Re: Design Advice Letter

The role of the Design Review Panel (**Panel**) is to provide independent, expert and consistent design advice on the design quality of a housing project seeking a design excellence competition exemption. The role of the panel is advisory only. The advice provided does not fetter the independence or role of the Consent Authority.

3.8 ACCESS & CIRCULATION DIAGRAM

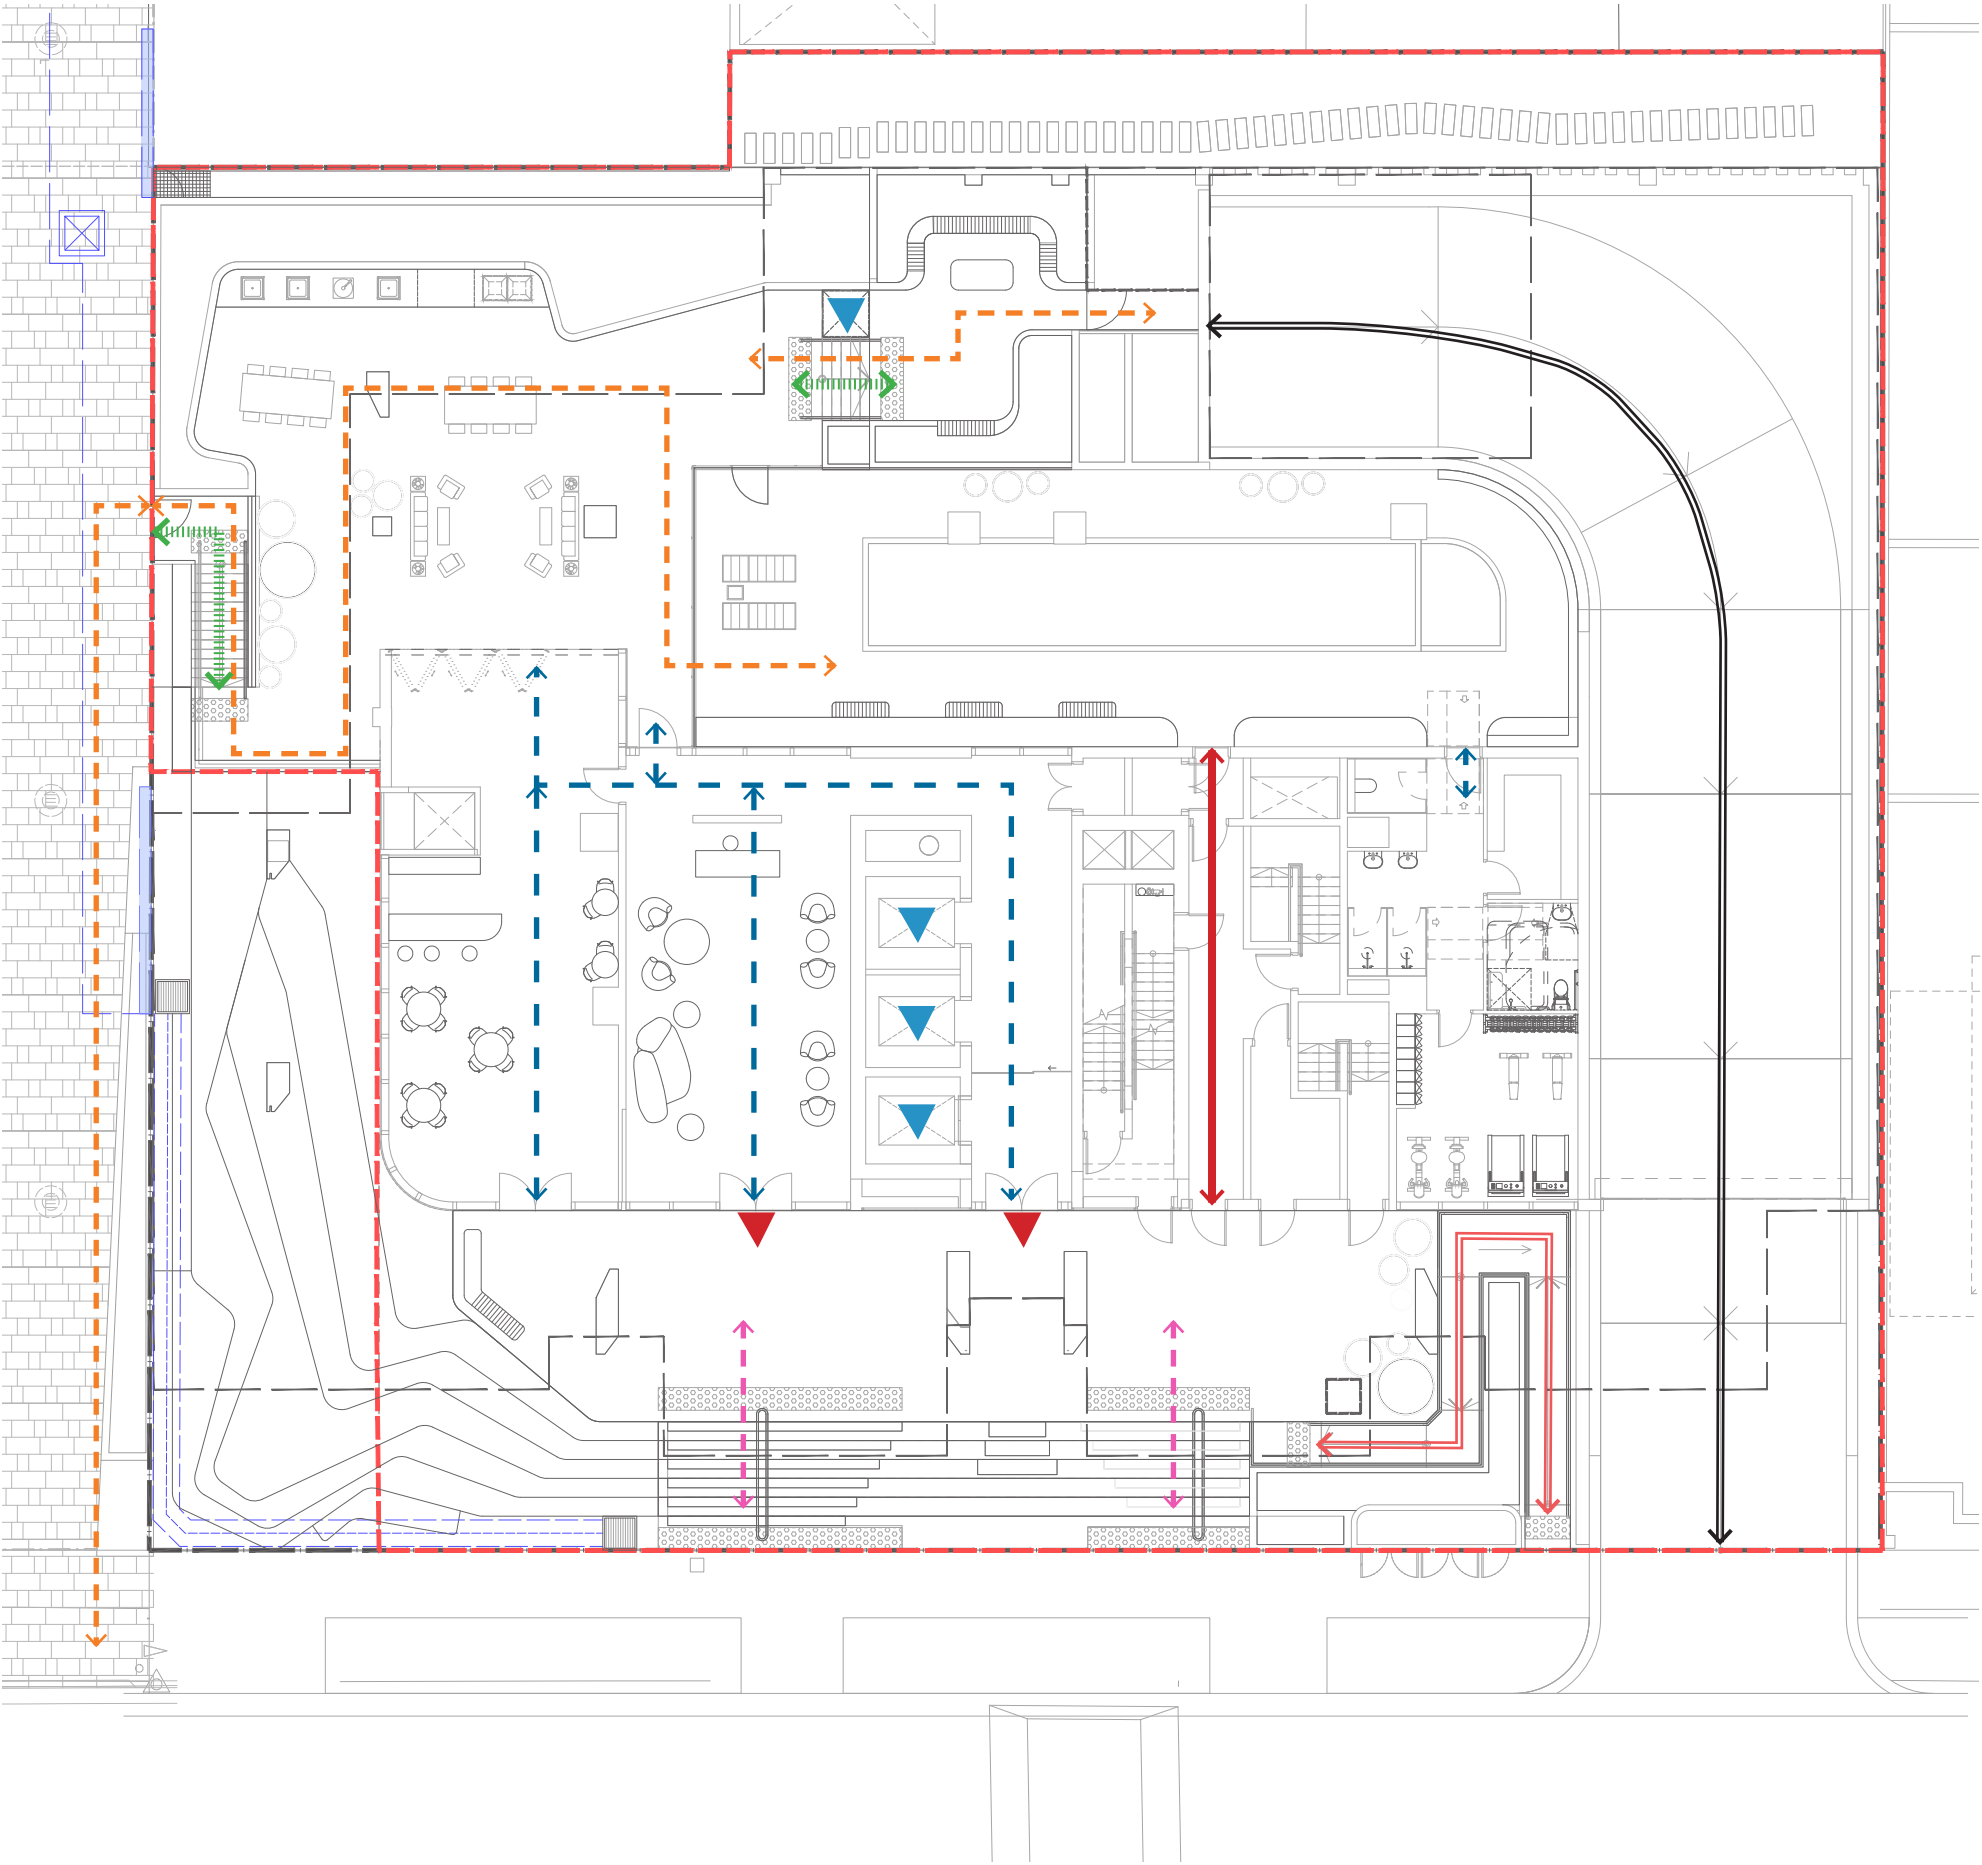
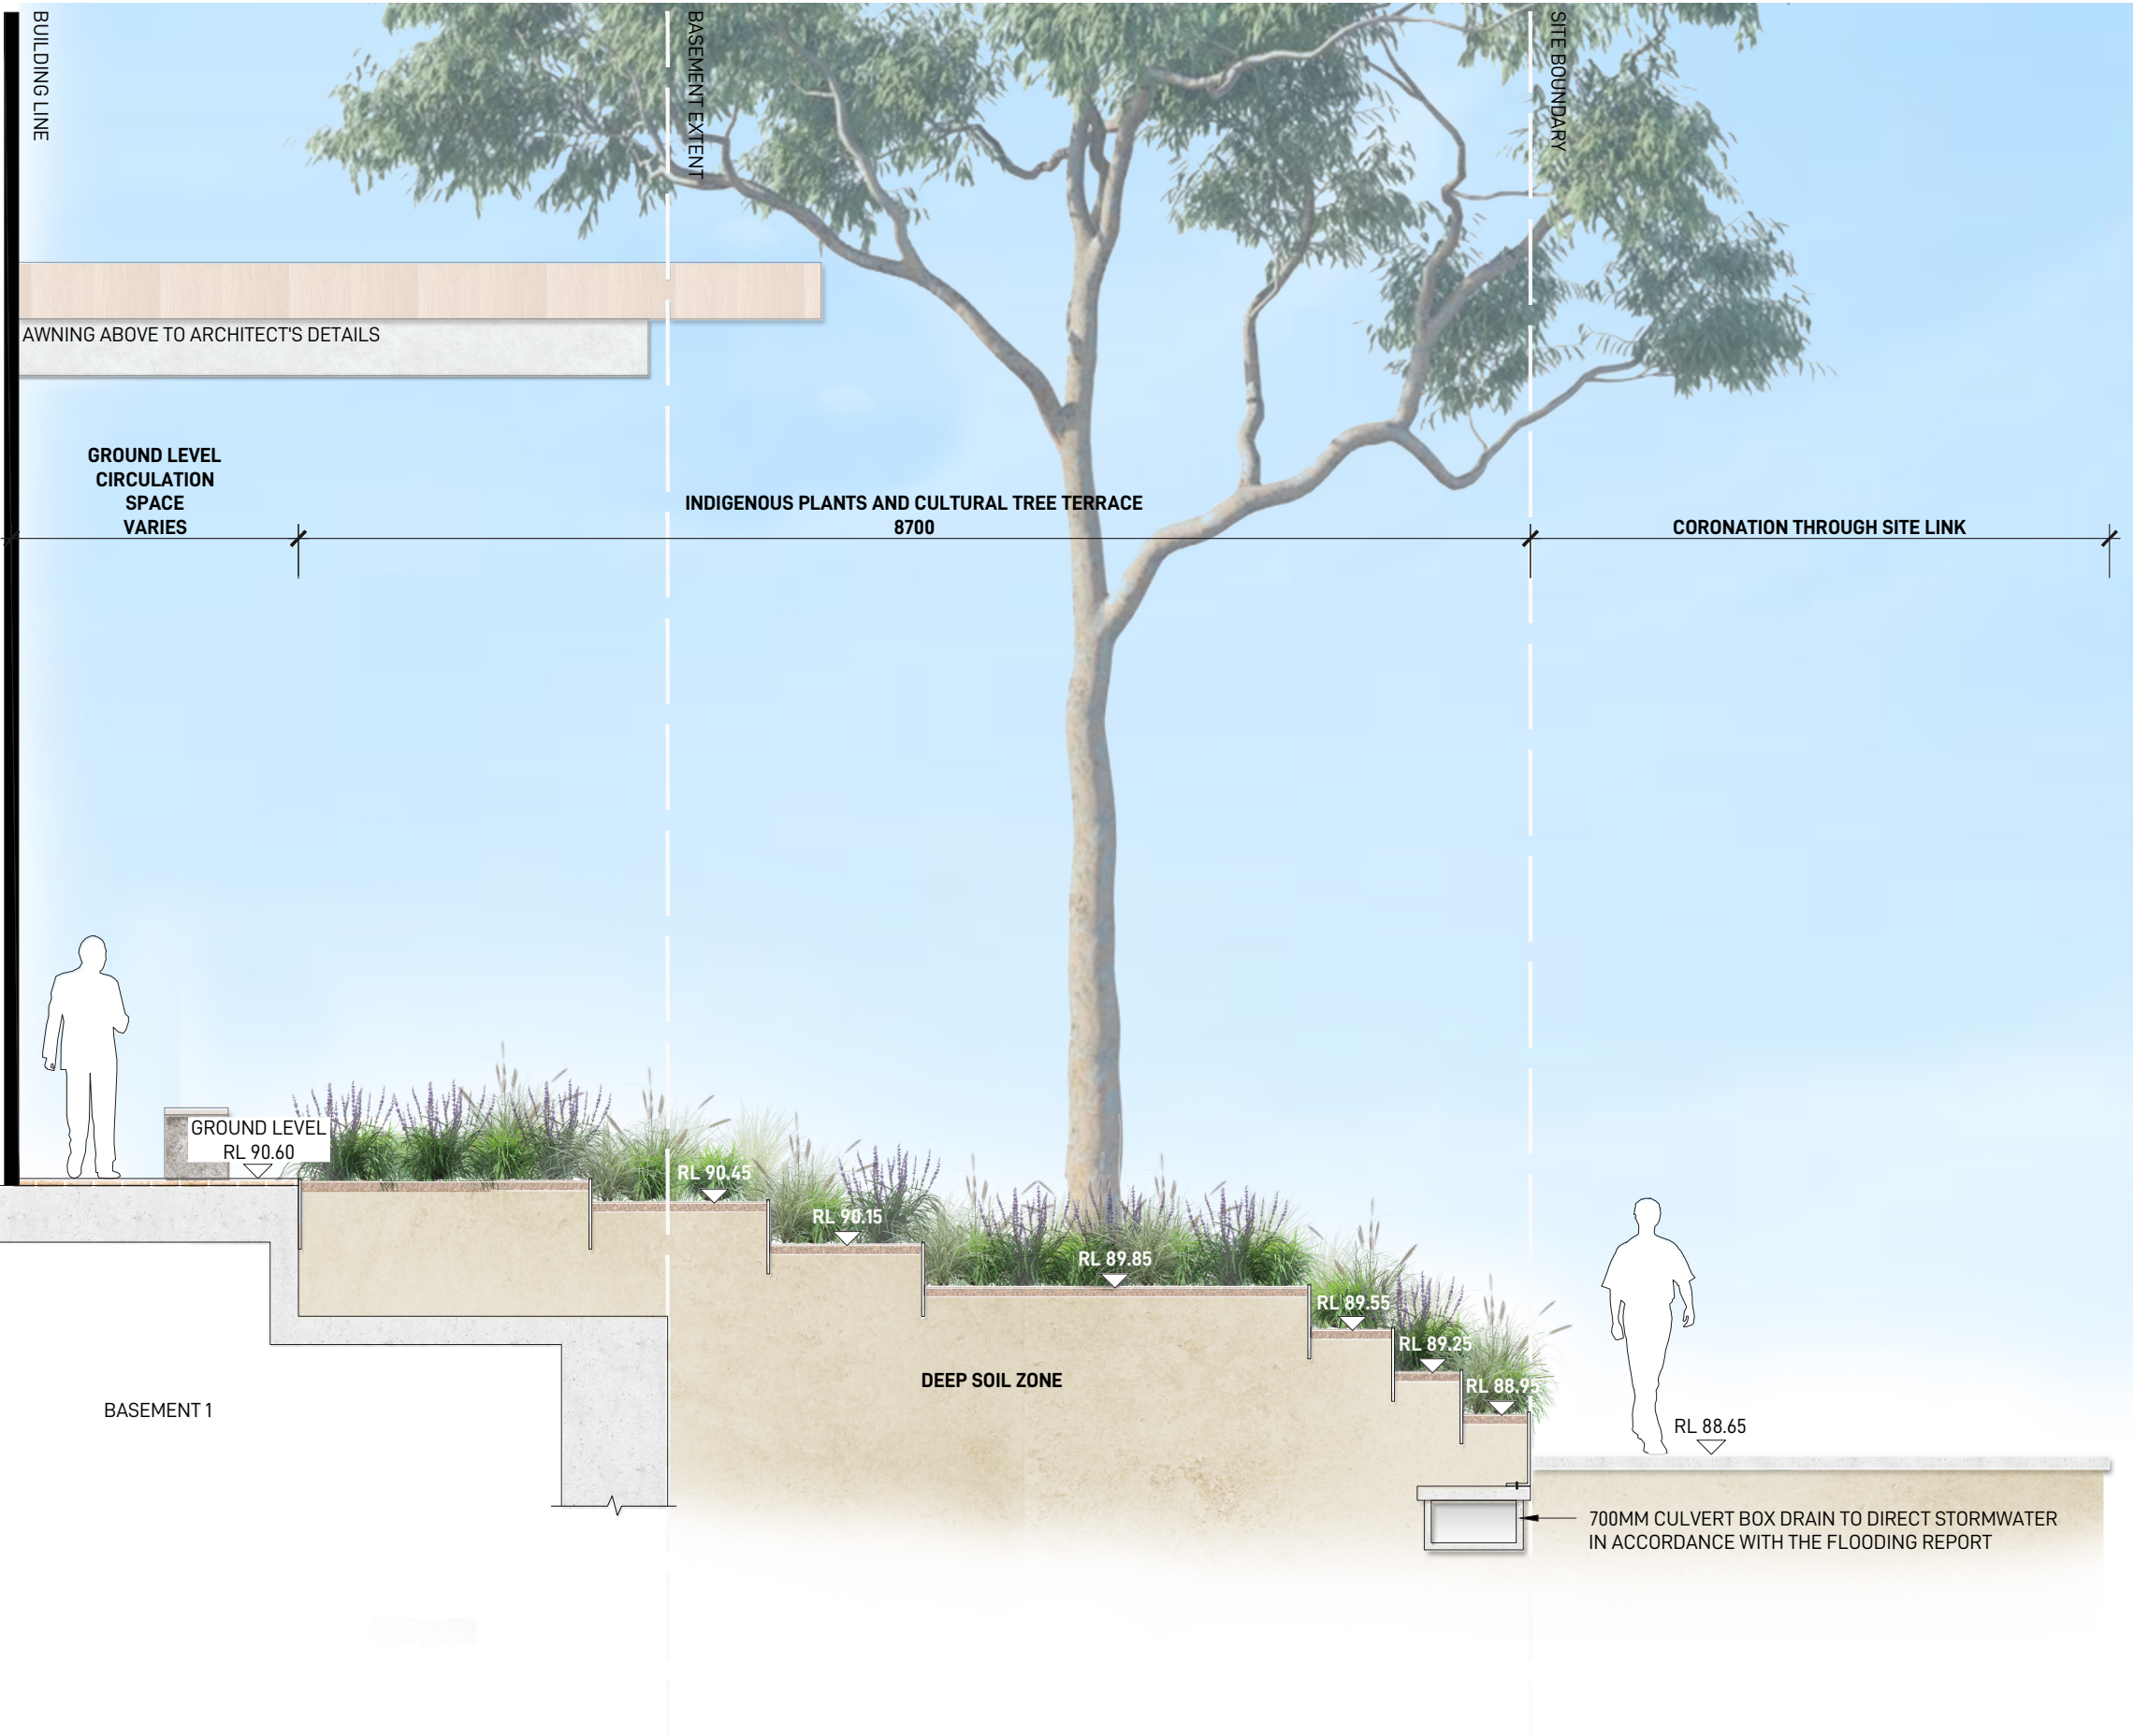
- The current design includes screening to the east for the access ramp. The design team is to demonstrate potential acoustic and fire safety concerns.

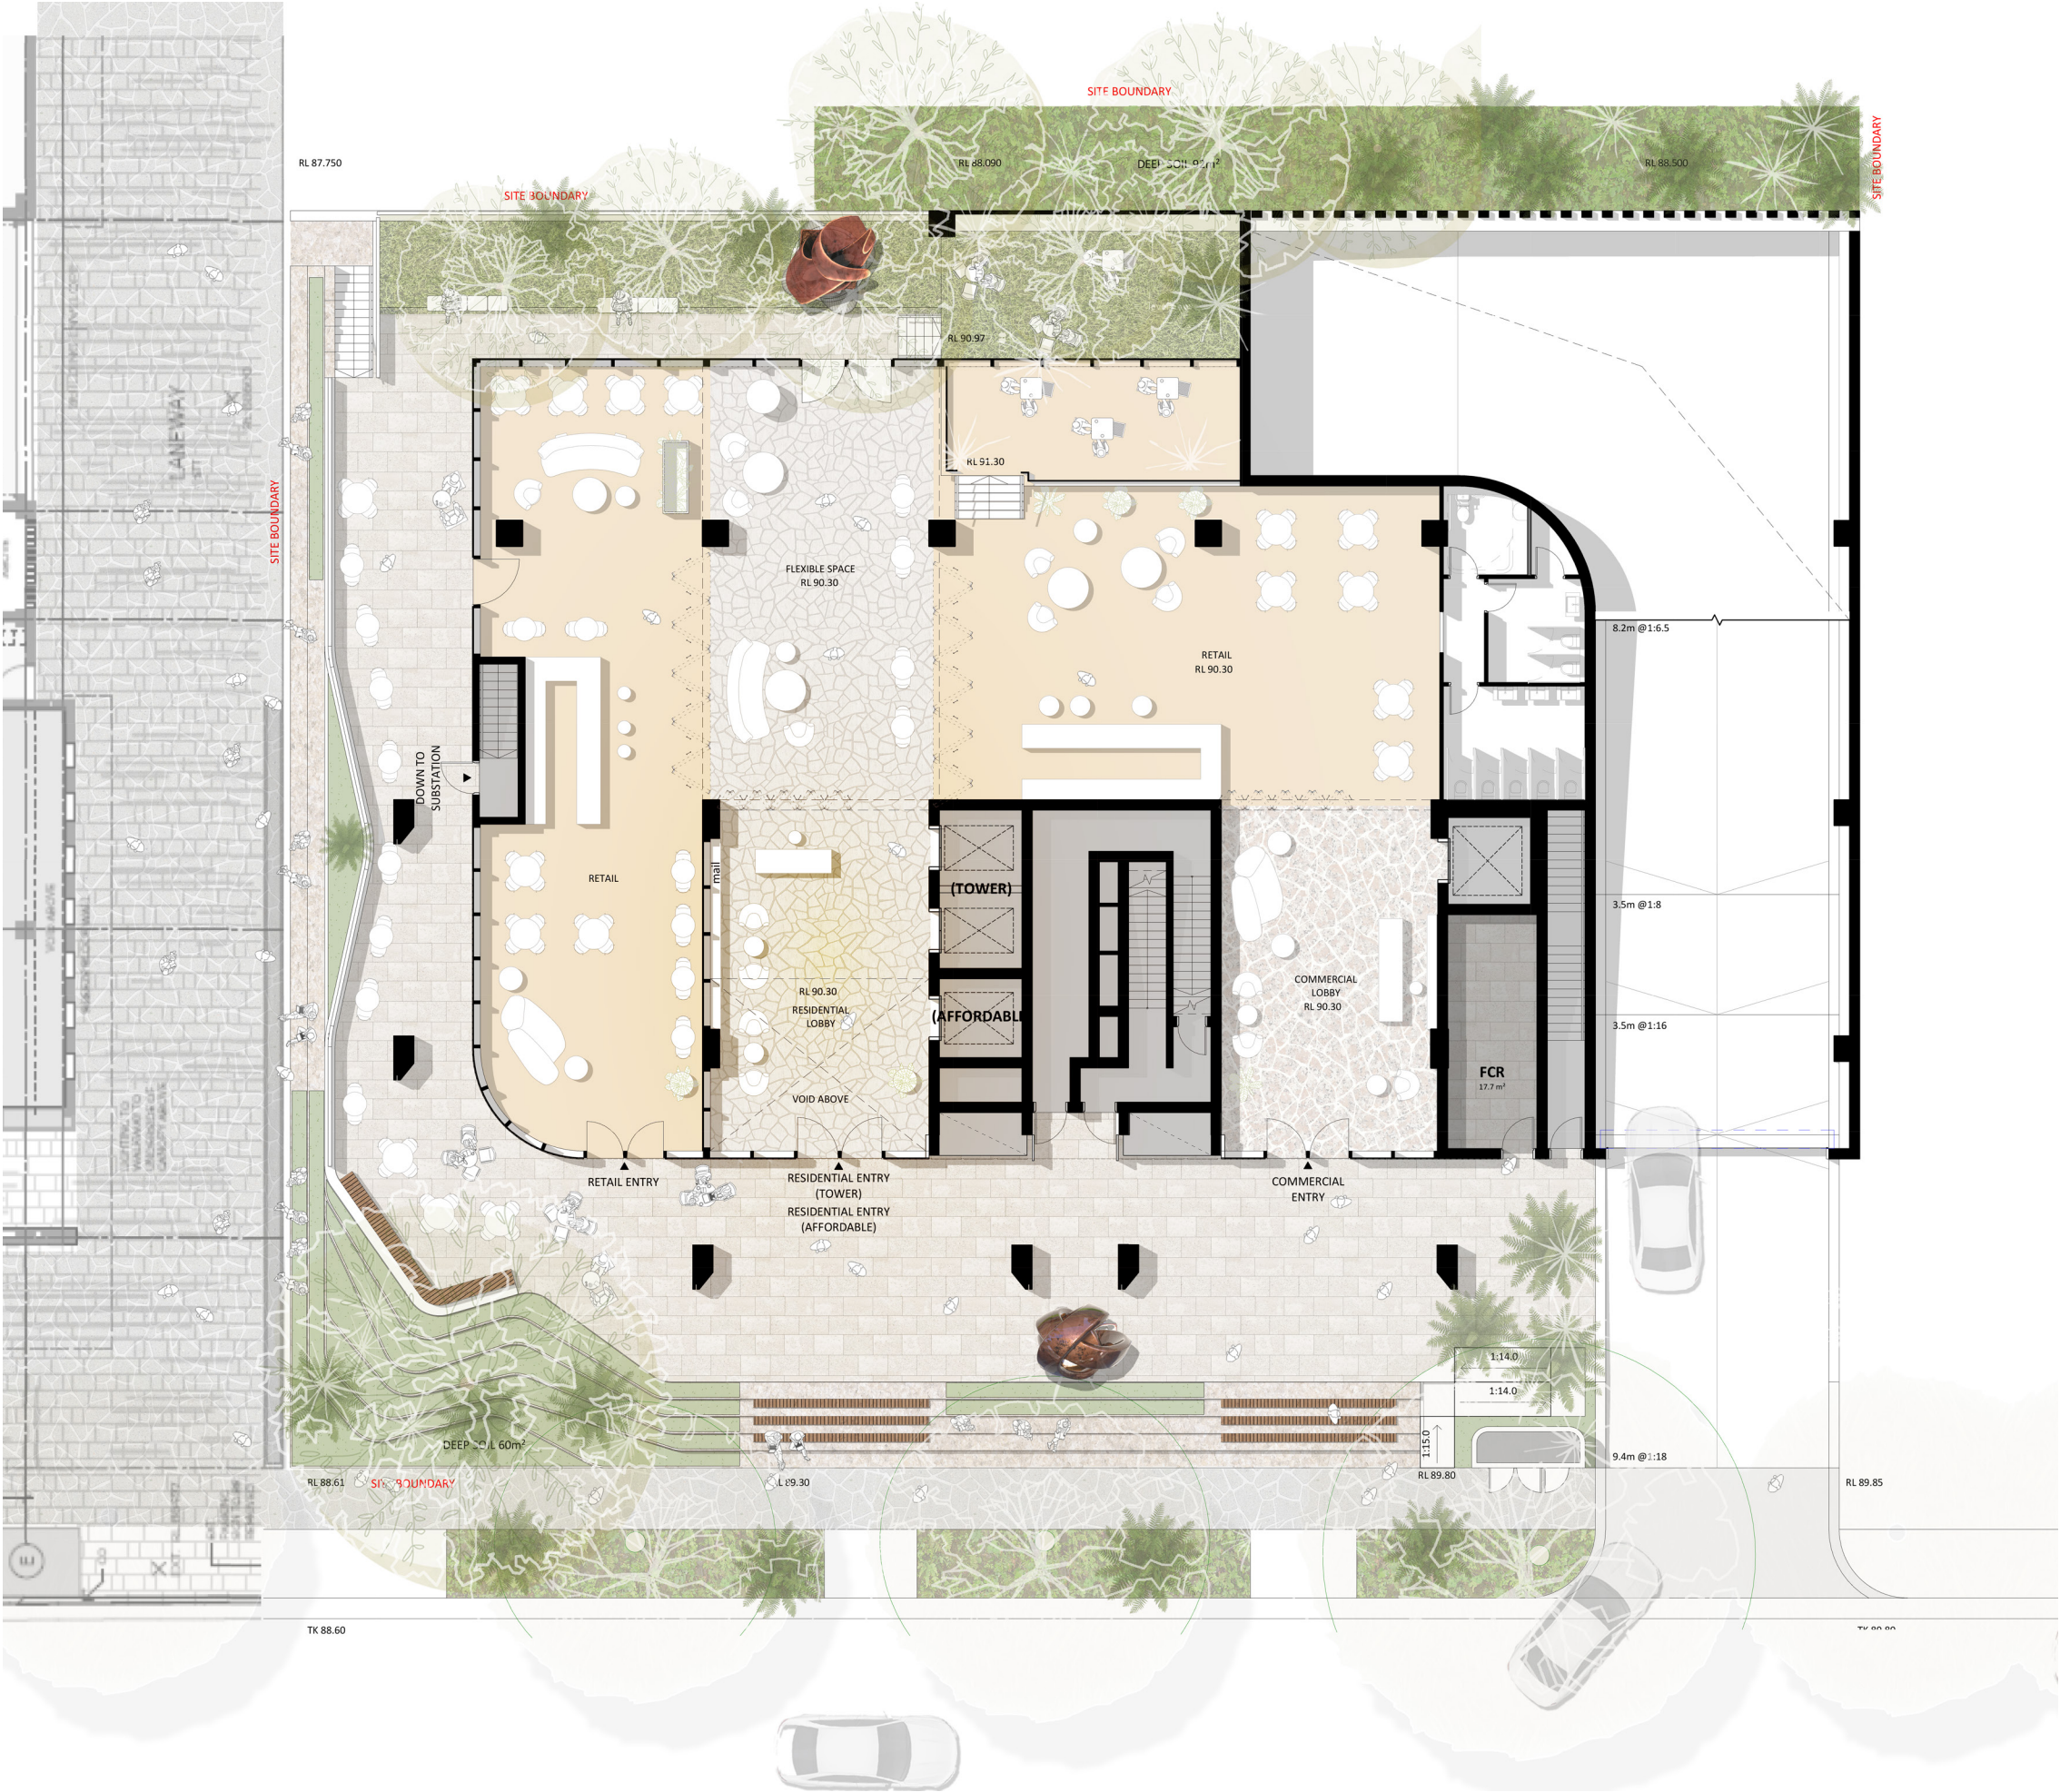
- The Panel commends the provision of a terrace at the north western corner, however the Design Team is to further explore the level changes between the northern communal space and the street level. The Design Team is encouraged to lower the level where possible to improve the relationship with the street level.
- Reconsider the appropriateness of the provision of stairs at northern interface. The Design Team is to explore alternative ways of activating the northern interface.
- Further consideration is to be given to the location of the object artwork and its potential implications to wayfinding and concealing the residential entries.

- The current layout of the residential lobbies is acceptable provided access to the communal facilities for the affordable housing residents are provided as per the diagram on page10 of the DRP Report submitted.
